CITY OF ALBUQUERQUE

Re: Paragon Electric Office & Shop, 1409 Ortiz Dr. SE,

Traffic Circulation Layout

Architect's Stamp dated 01-02-12 (L18-D030)

SHEET TITLE:  
Site Details

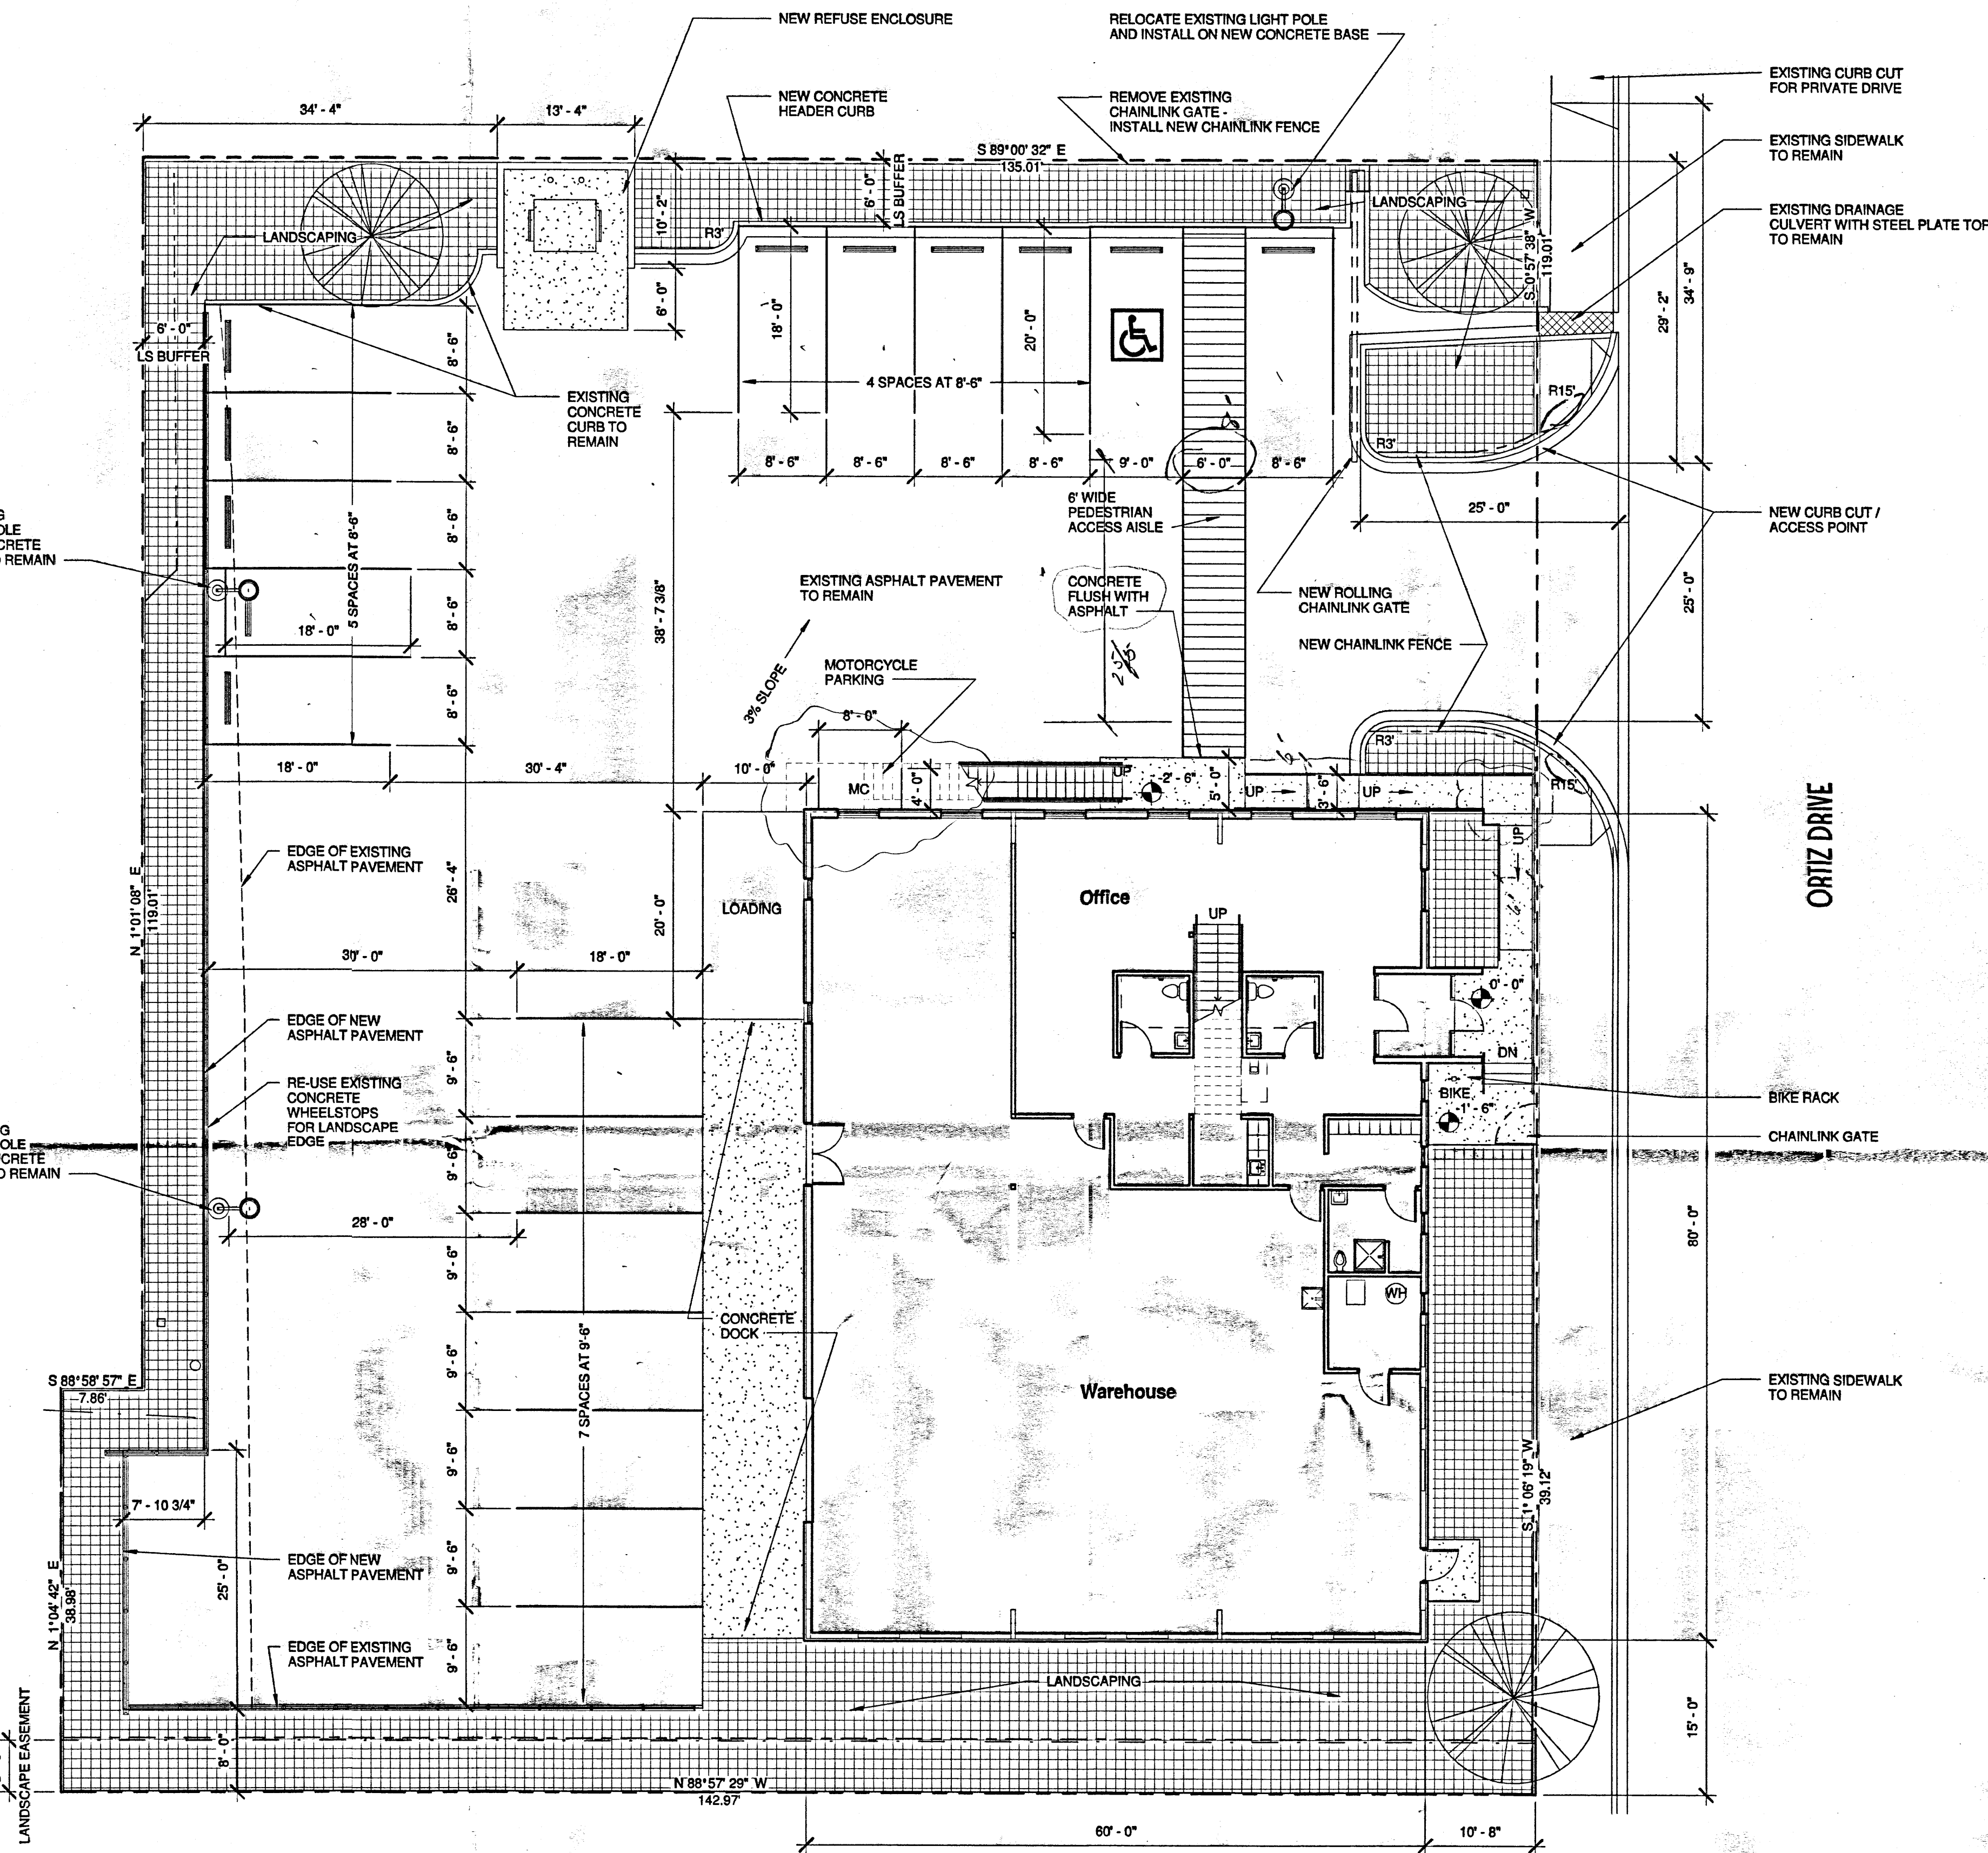
3. A 6-foot wide, ADA accessible pedestrian pathway is required from the public sidewalk to the building and from the ADA parking stalls to the building. Provide details for the proposed ramp shown adjacent to the building. Note that the rise for any ramp run shall be 30 inches maximum, ramps shall have landings at the top and bottom of each ramp run, and handrails are required on ramp runs with a rise greater than 6 inches (Sections 405.6, 405.7, and 505.1, *Americans with Disabilities Act and Architectural Barriers Act Accessibility Guidelines*, United States Access Board, Jul 23, 2004).

9. Identify all ramp slopes or provide a detail clarifying the max slope of 12:1.
10. Include a copy of Solid Waste approval with the next submittal.
11. It appears the "stairway," located on the northwest corner of the building, conflicts with the loading area/dock. Please clarify what will take place in this area.

SHEET TITLE: Traffic Circulation Layout Plan

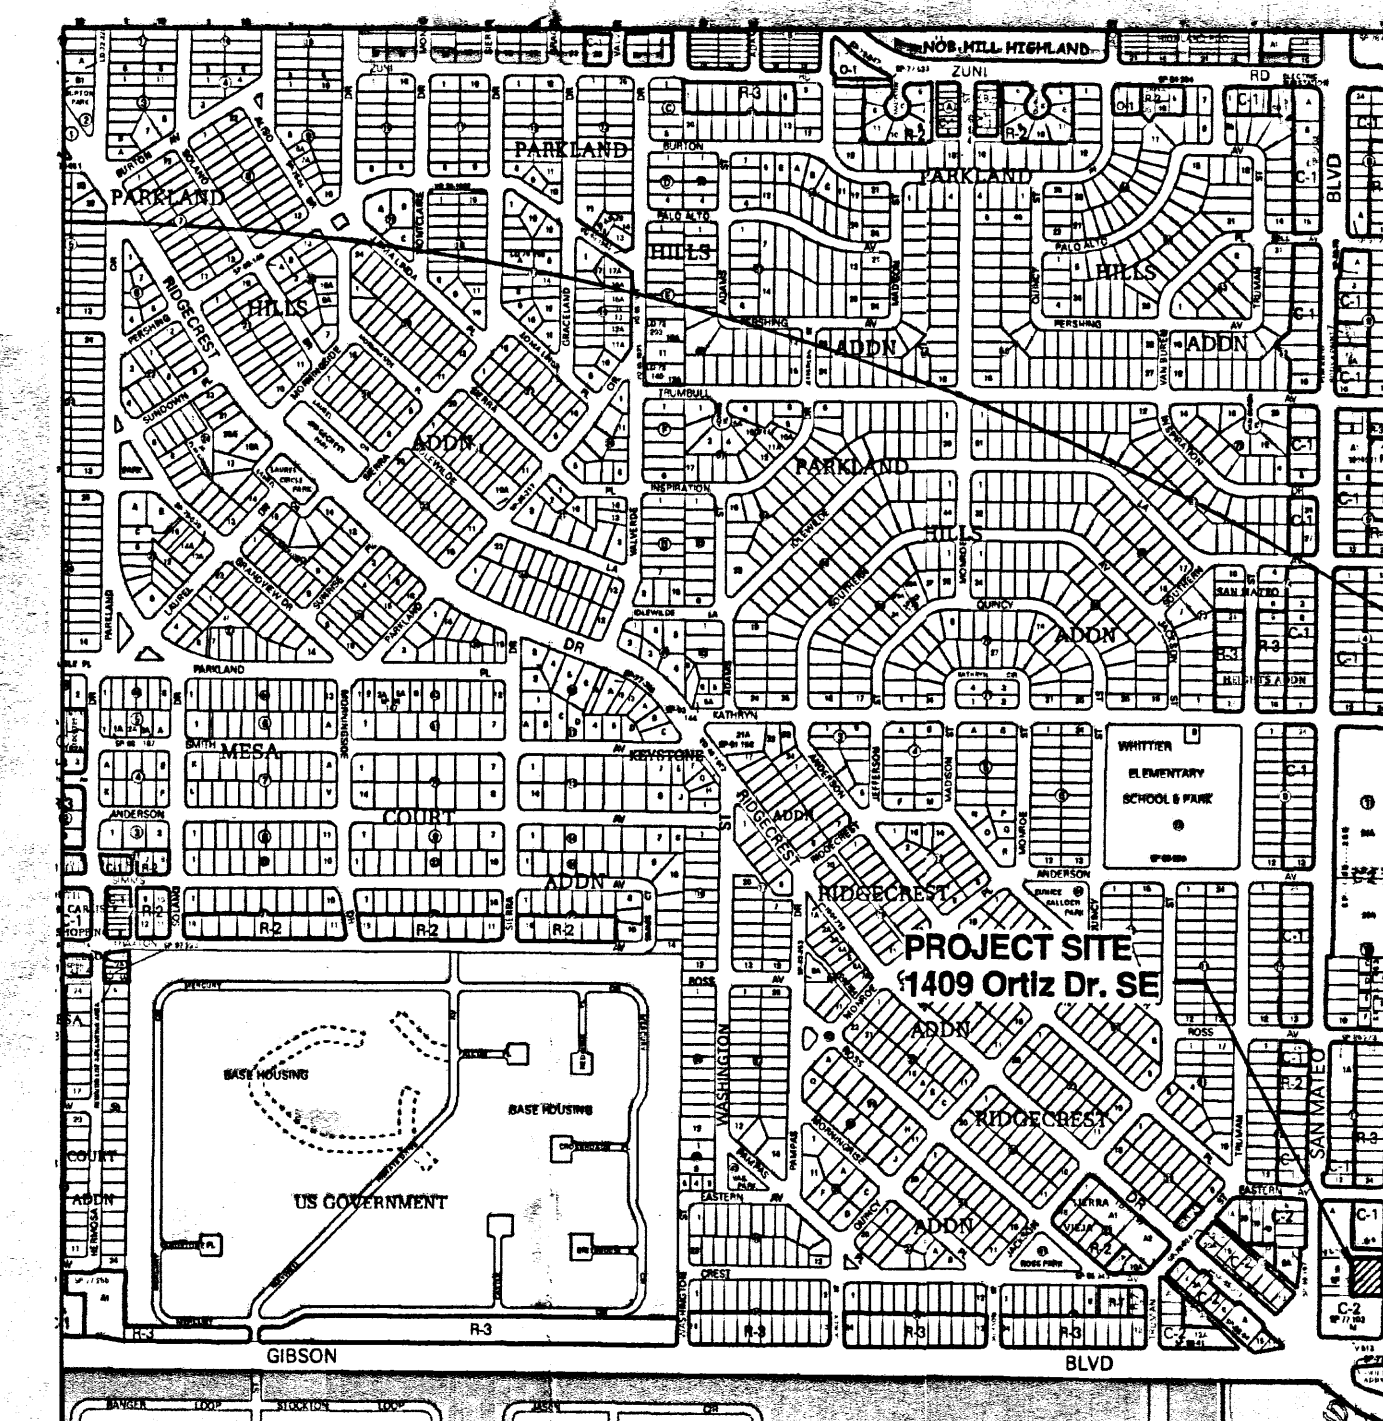
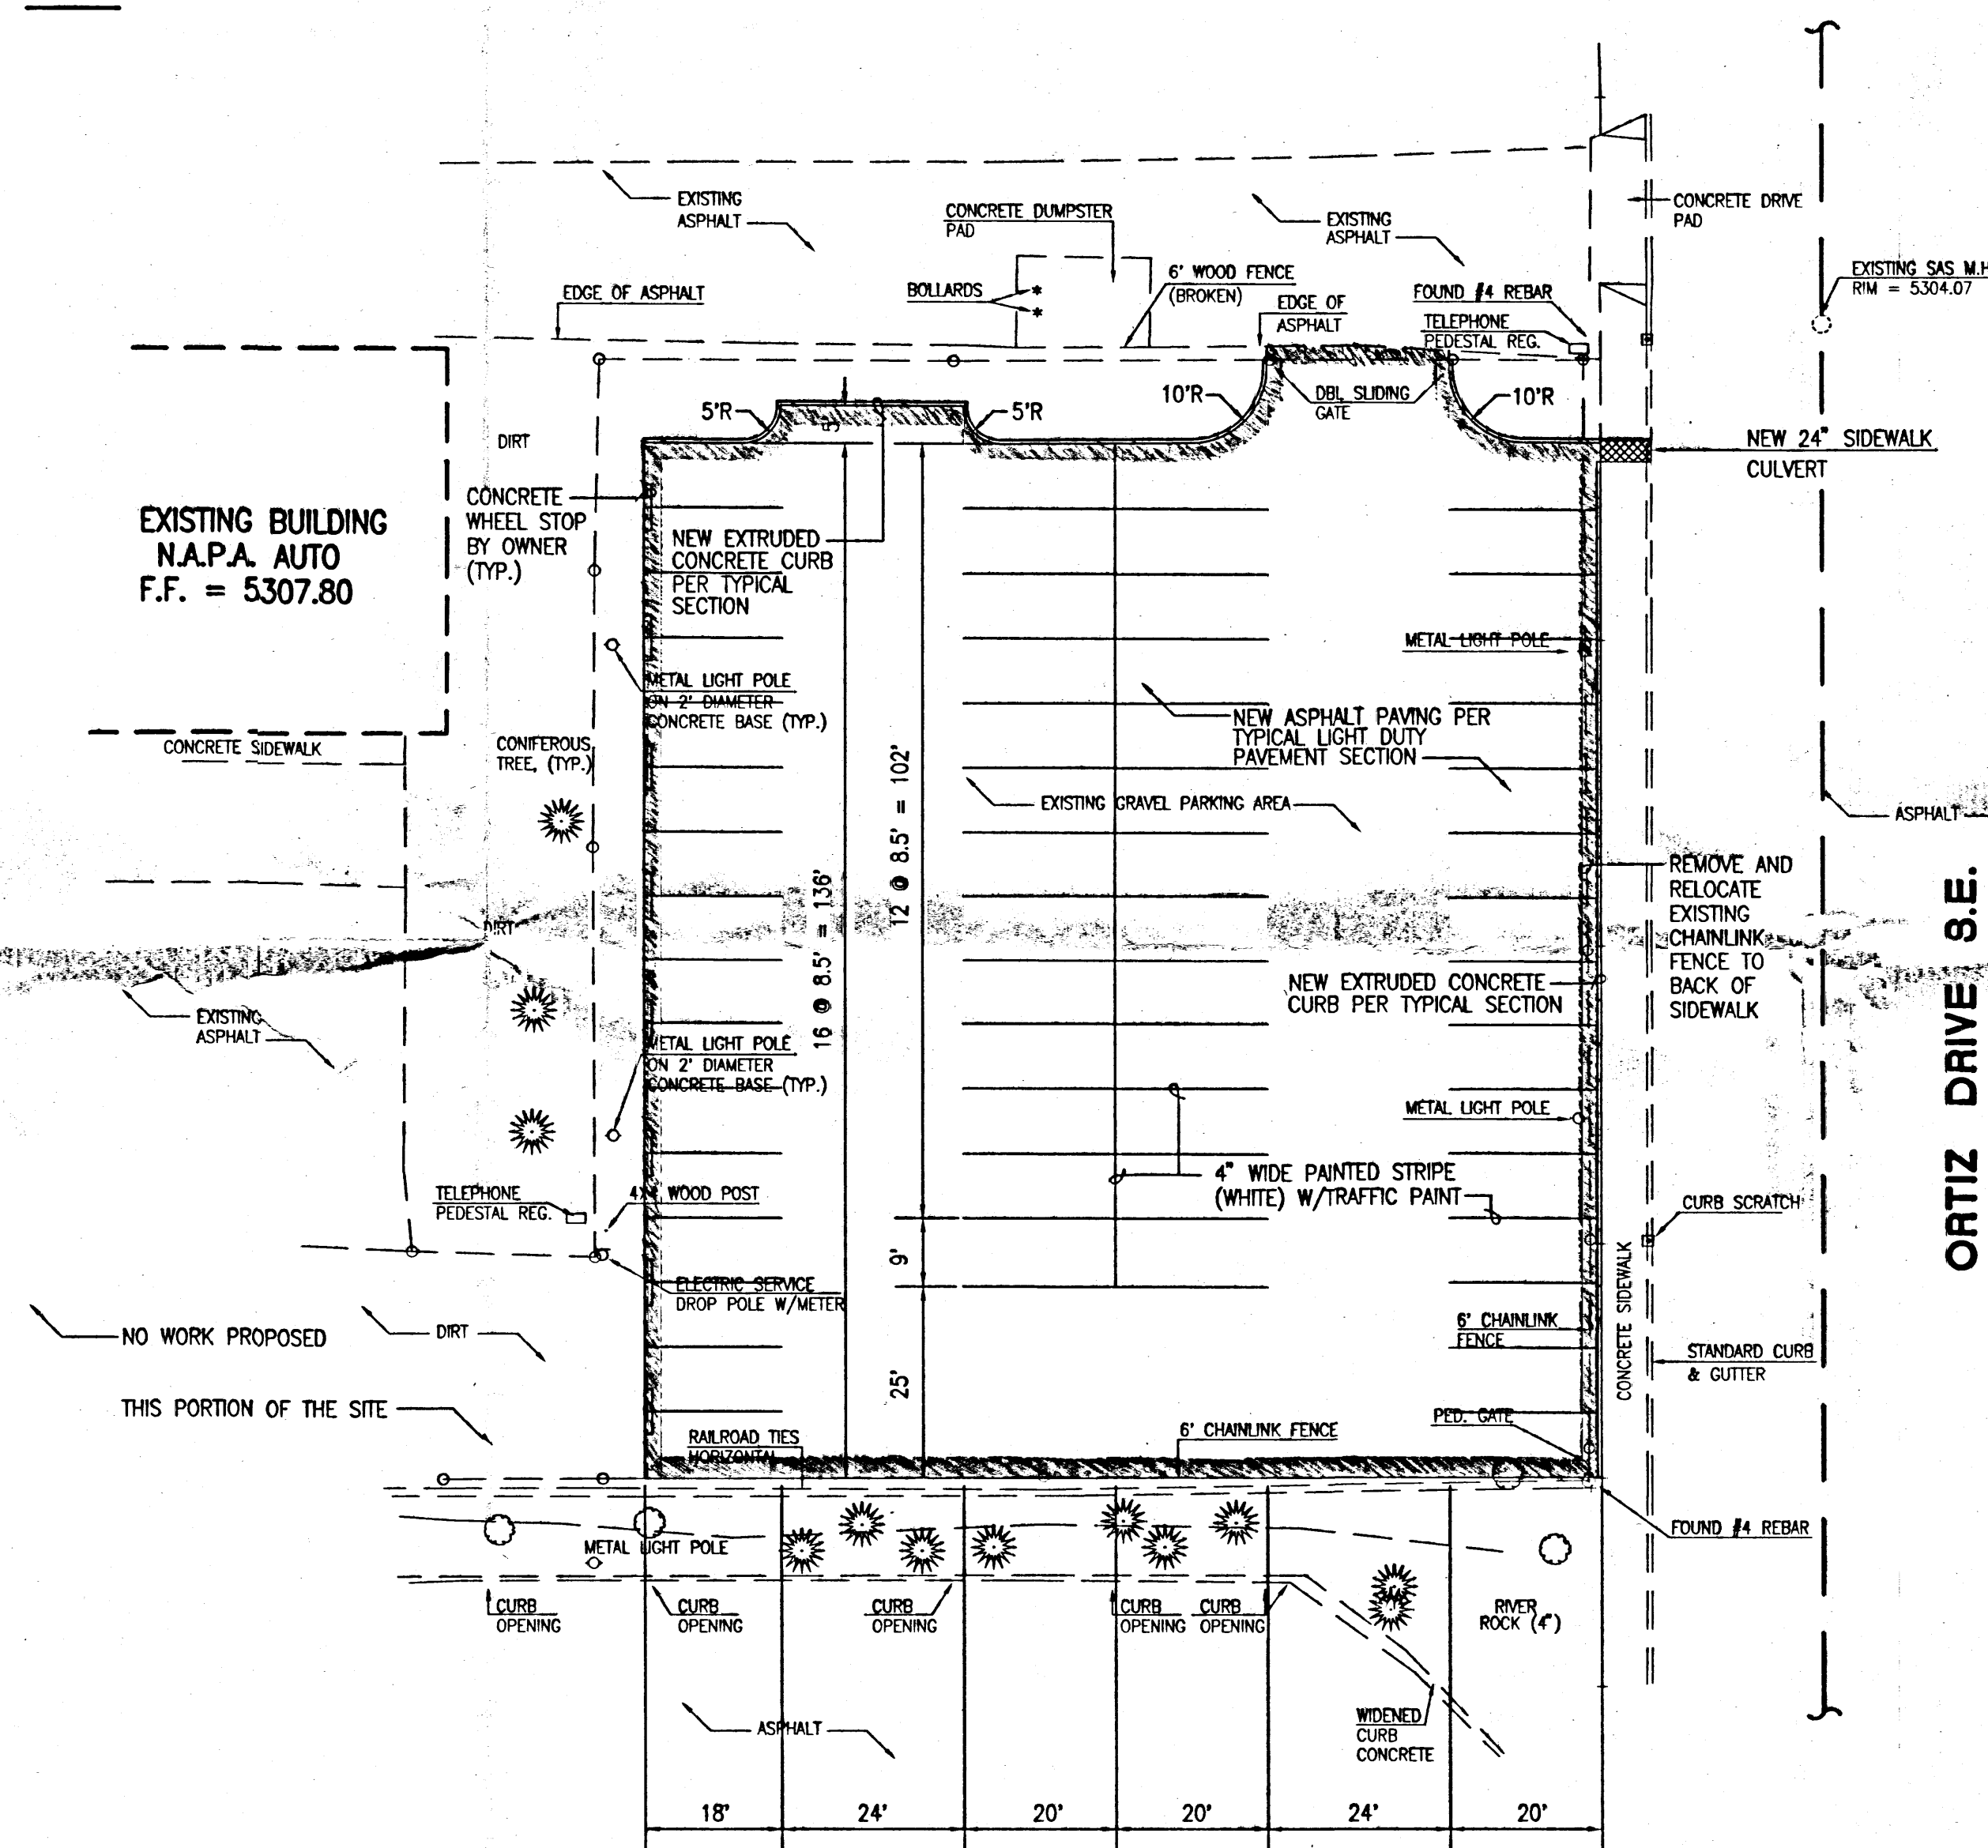
1. The handicapped spaces must include an 8-foot wide van access aisle; all other aisles should be 5 feet in width.
2. Please include two copies of the traffic circulation layout at the next submittal.

4. Define width of the existing sidewalk.
5. Please refer to all applicable city standards.
6. All internal sidewalk must be a minimum of 6 feet in width.

7. Clarify how the internal sidewalk will be separated from the vehicular way. A curb is recommended.
8. All ramps located within City right of way must have truncated domes.
